Maritime &
Coastguard
Agency

Application by Equinor for an Order Granting Development Consent for the Sheringham and Dudgeon Extension Projects.

Deadline 8 – Rule 17 Letter Requesting Further Information

Offshore Works Plans (without prejudice) – scenario
1(a)

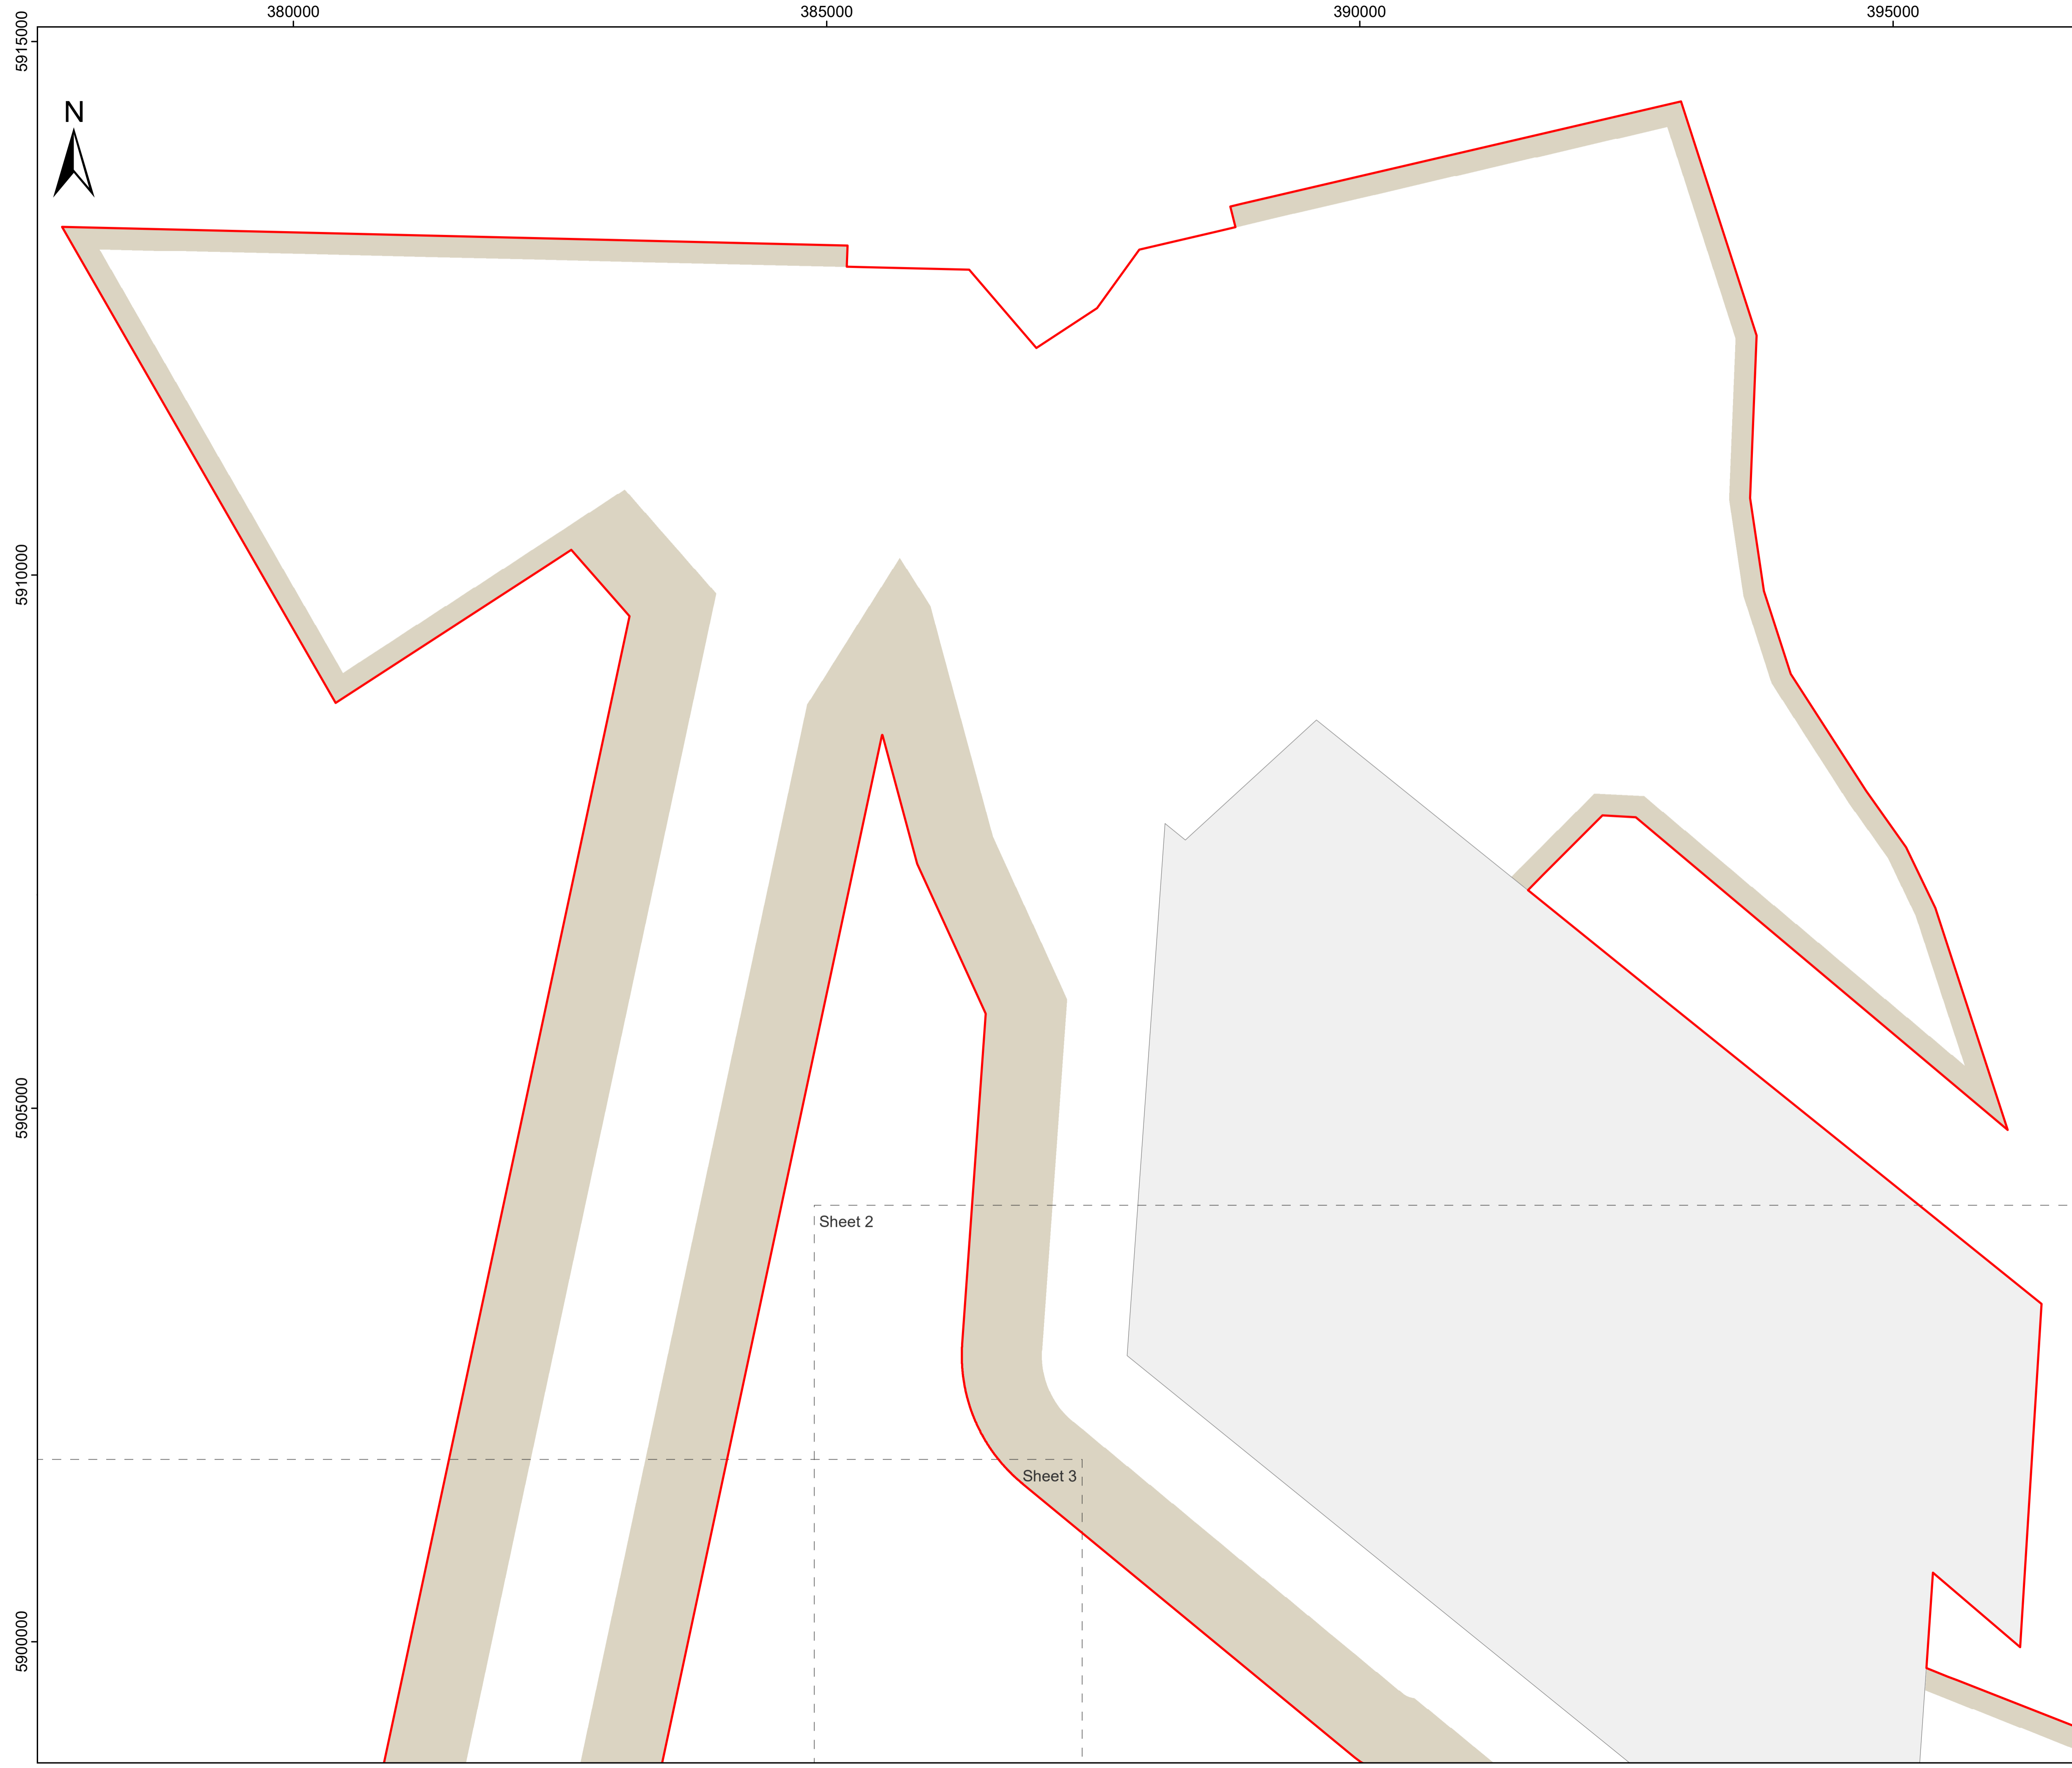
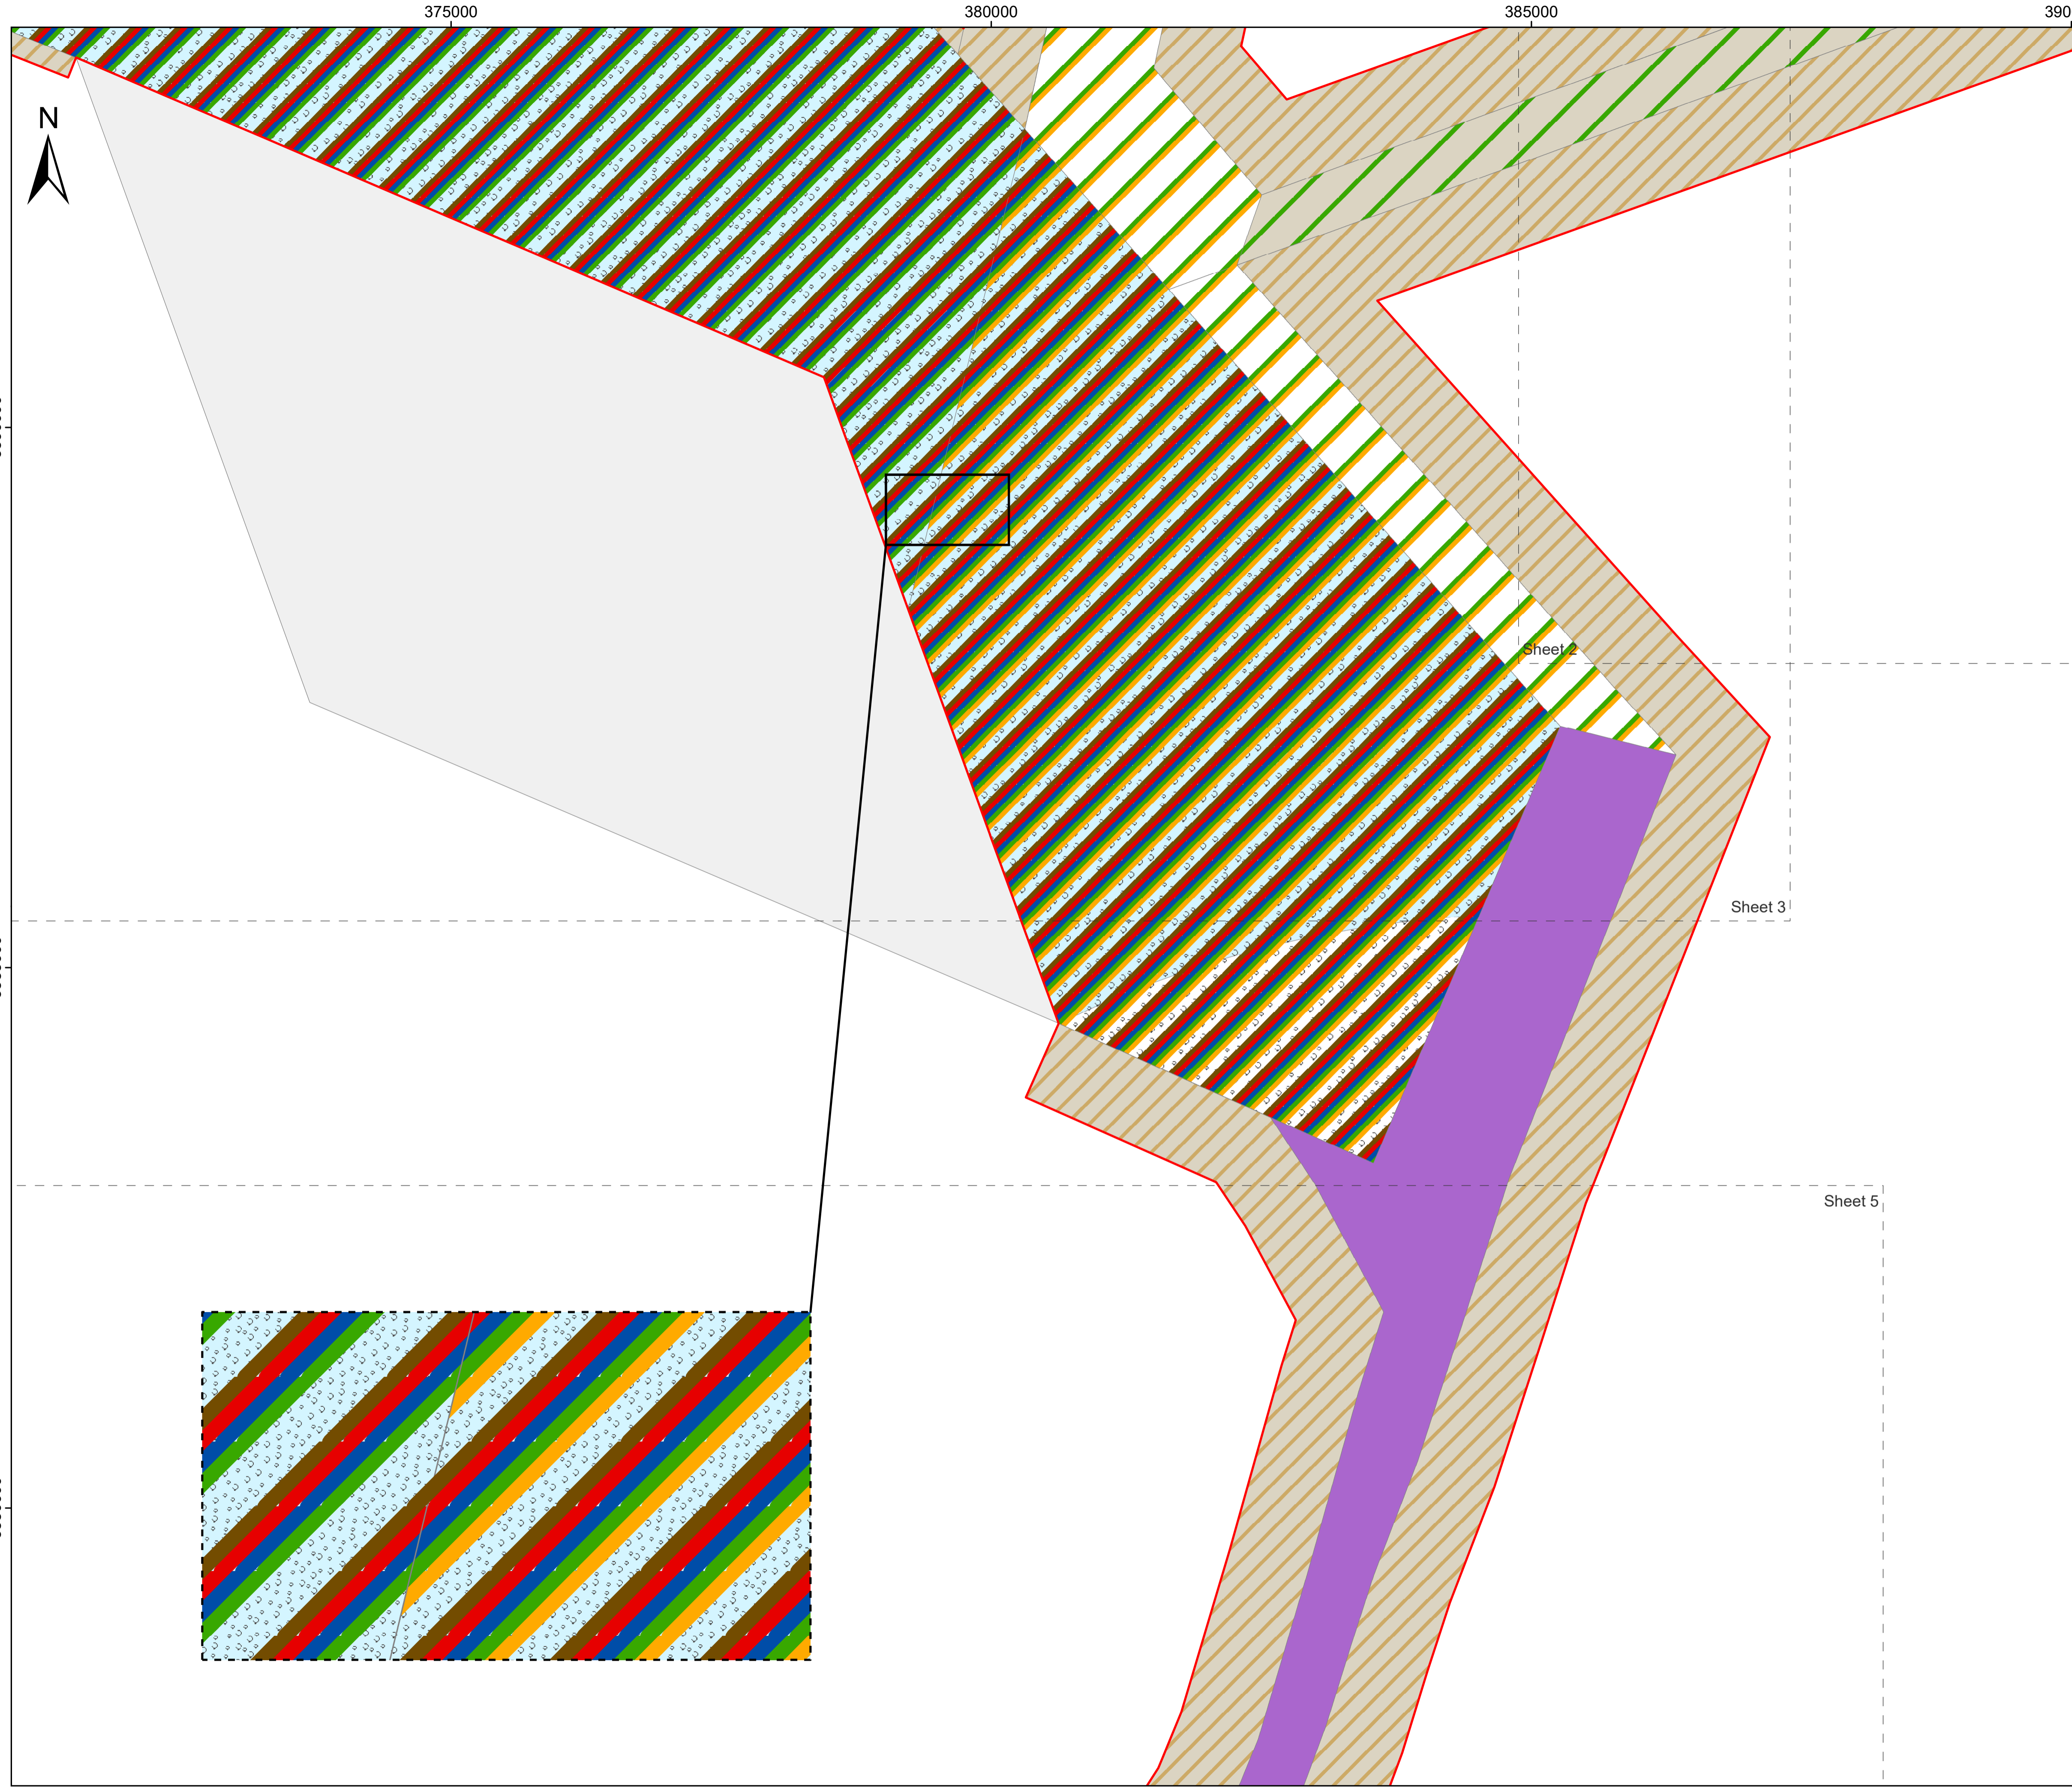
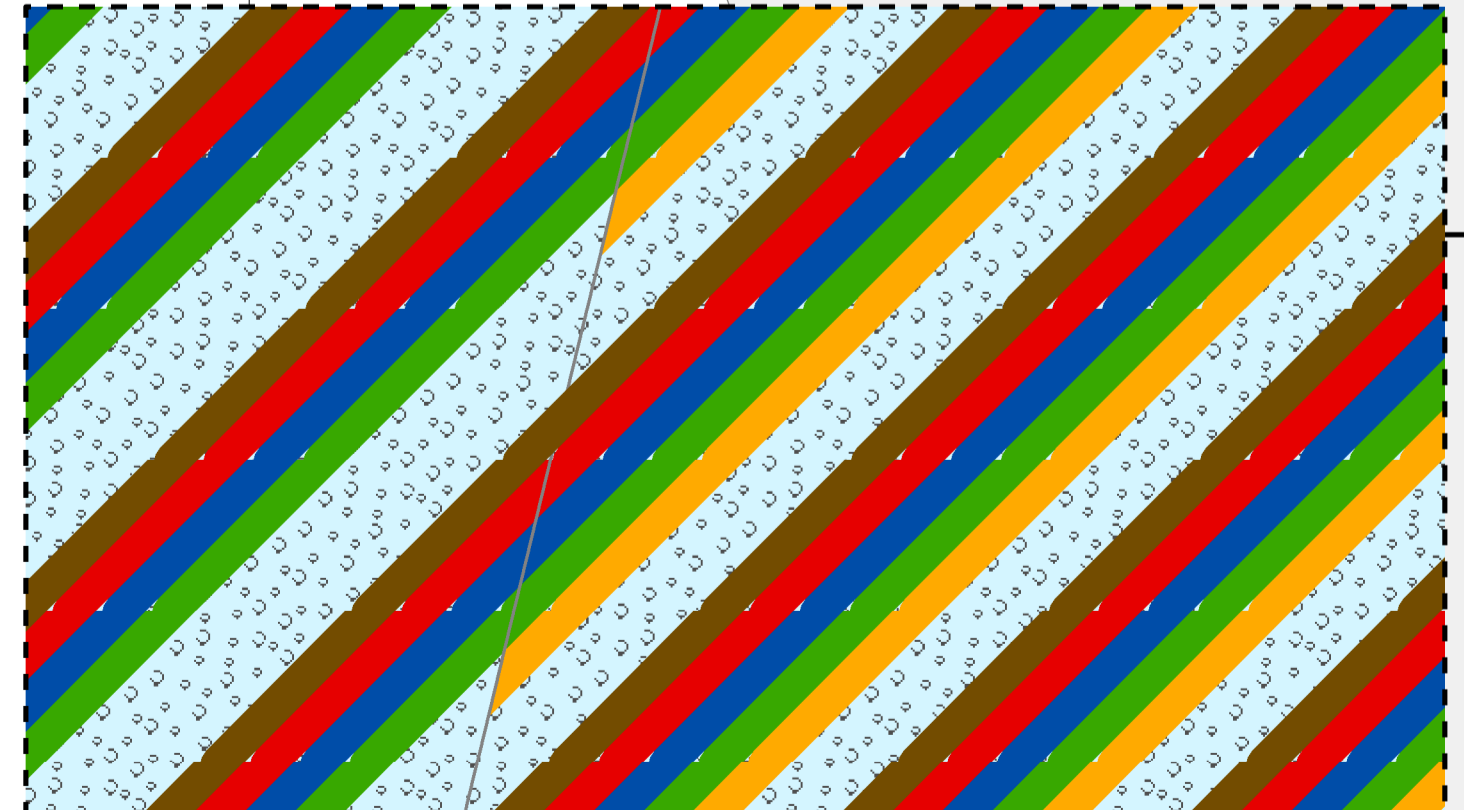
In the Applicant's response to ExAQ4 they state that "*an alternative without prejudice surface structures free area*" was provided in the Offshore Works Plans (Without Prejudice) [document reference 2.7.2], submitted at Deadline 7 to shows a surface structures free area that complies with the MCA's calculation for adequate sea room to allow four vessels to safely pass each other in the Outer Dowsing Channel. The images in this document are not presented on a navigational chart and are without calculations on the sea room so they are inadequate for graphically representing that sea room is sufficient.
